From: Plater, Roger - Communities <Roger.Plater@Oxfordshire.gov.uk>
Sent: 15 September 2020 16:35
To: Bob Neville
Cc: DC Support; Cllr Arash Ali Fatemian
Subject: 20-02152-F 13 Blackwood Place Bodicote

Planning application: 20/02152/F
Location: 13 Blackwood Place Bodicote Banbury OX15 4BD
Description: Erection of dwelling house, garage and associated vehicular access off Oxford Road A4260.
Type: Full Development
Case Officer: Bob Neville

**GROUND FLOOR PLAN**

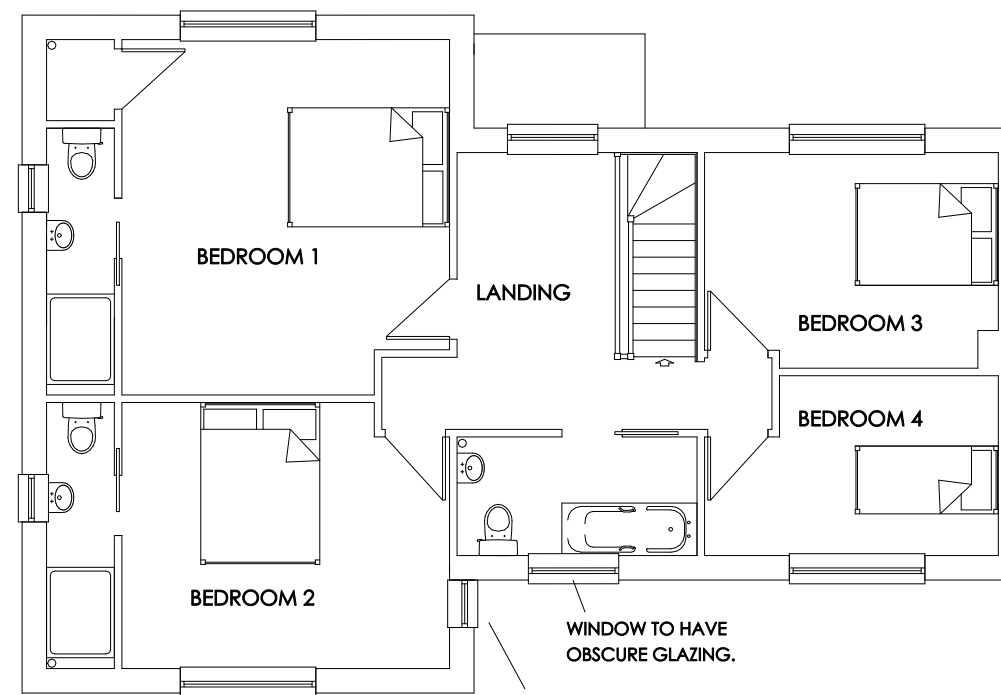
As the garage has an internal length of 5.4m it cannot be counted as a parking space. However, there is adequate area to accommodate at least two spaces outside while maintaining space to turn.
